SOUTH  
KESTEVEN  
DISTRICT  
COUNCIL

**Application by Mallard Pass Solar Farm Limited for Mallard Pass Solar Project  
The Examining Authority's written questions and requests for information (ExQ1)  
Issued on 23 May 2023**

**Responses by South Kesteven District Council  
15 June 2023**

Figure 3-1: Construction Routes Overview

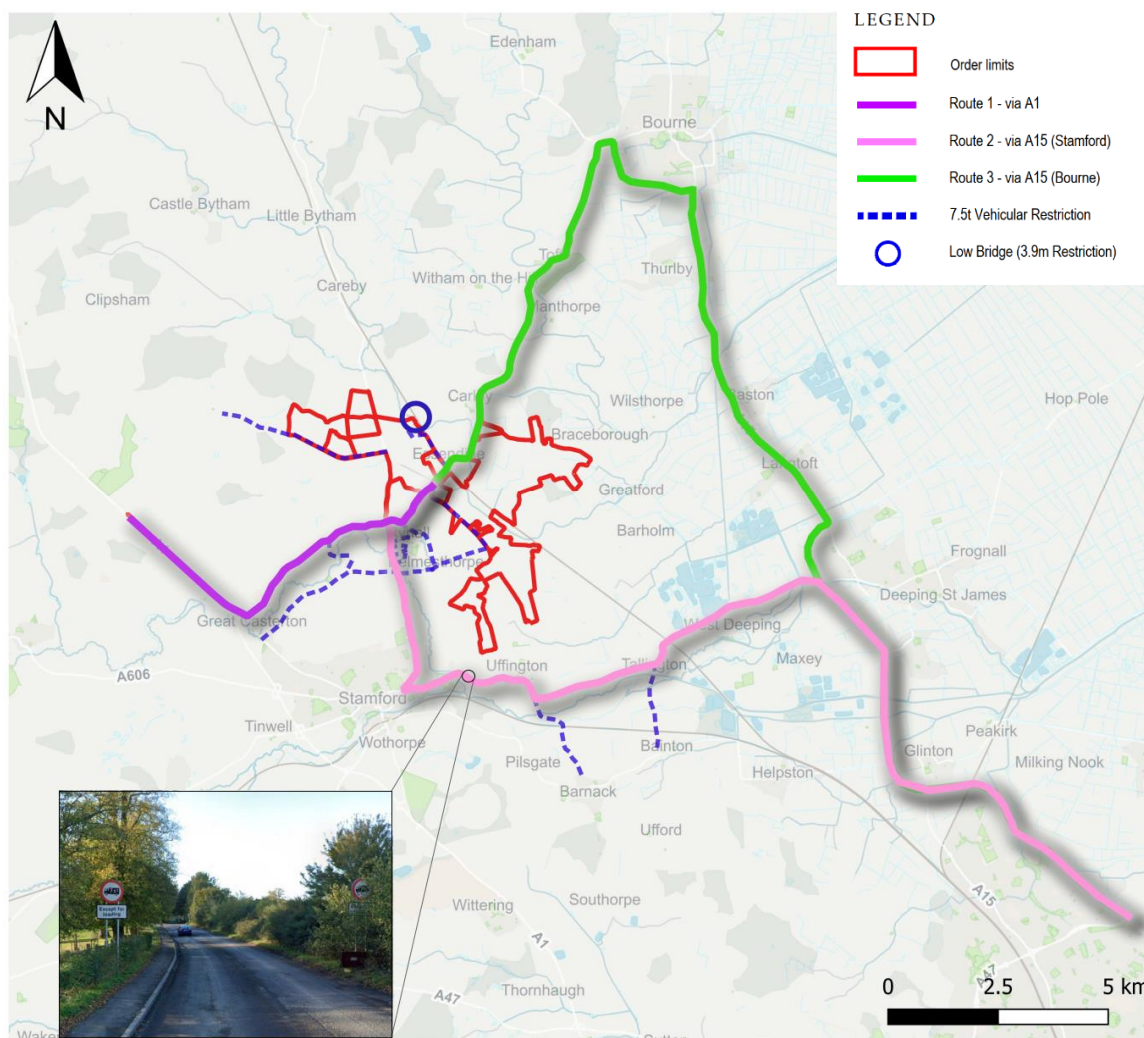
*Casterton / Rutland) and out via Route 3 (via A15 at Bourne / Lincolnshire). However, no assessment regarding the suitability of the B1081 / Ryhall Road or B1176 / A6121 T-junctions have been undertaken.*

*Section 3.2 Routing – There are no definitive plans of the local roads provided confirming the recommended HGV construction routes to and from the site or existing weight and height limit restrictions. This could lead to confusion for delivery drivers approaching / leaving the site, resulting in HGVs on unsuitable roads.*

Figure 3-2: Construction Routes from Primary Compound to Secondary Compounds

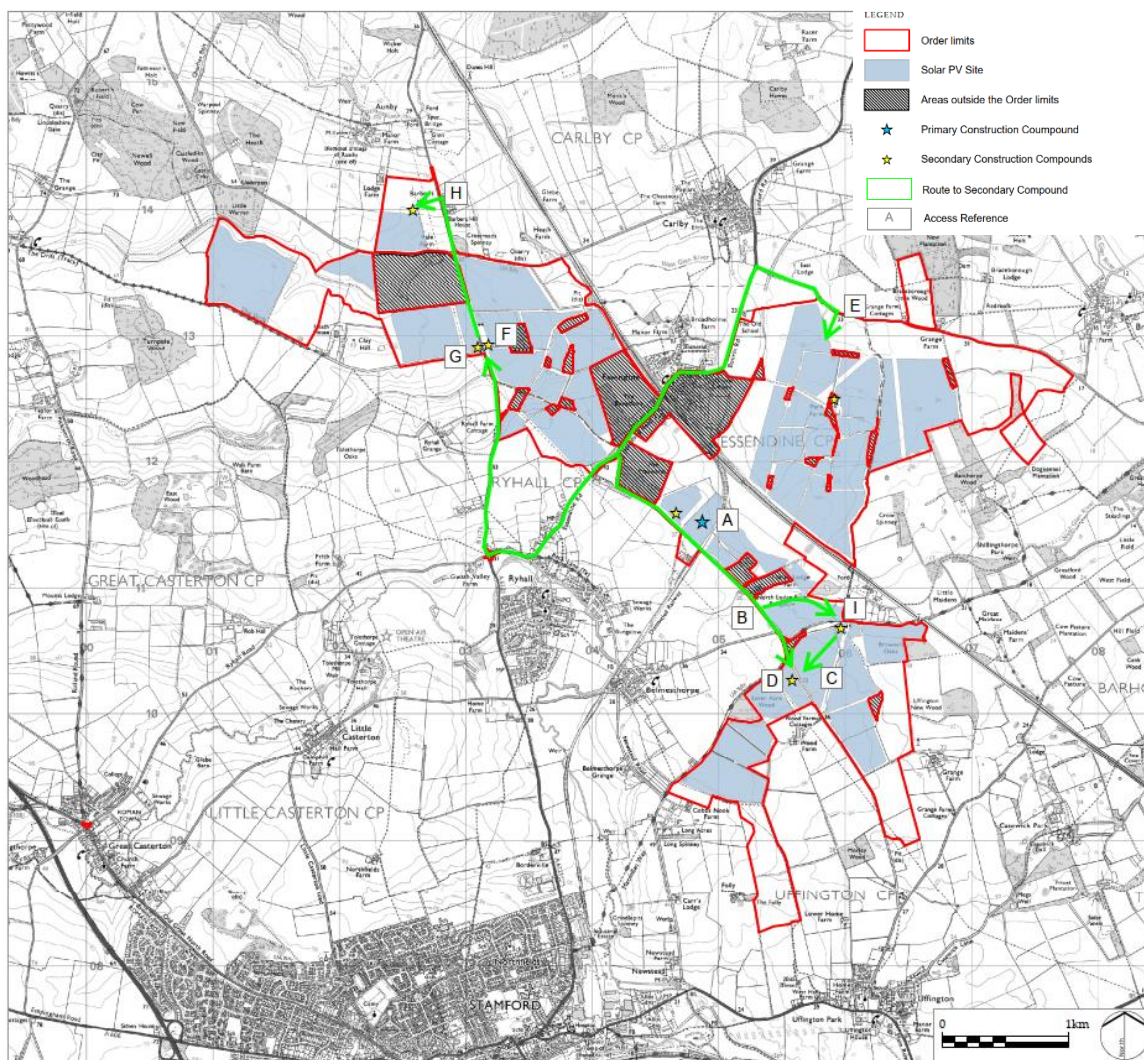
- a) Whilst swept path analysis has been provided at the access points, no assessment of how the tractors and trailers, 16.5m articulated lorries (carrying the inverters that cannot be broken down), or cranes would be able to travel to / from the primary and secondary compounds on the local roads.*
- b) No assessment of whether the above vehicles could pass a car along the route has been demonstrated and therefore residents who use these roads on a daily basis may meet an oncoming delivery and get stuck given the size of the vehicle and narrowness of the carriageway. What mitigation would be in place?*
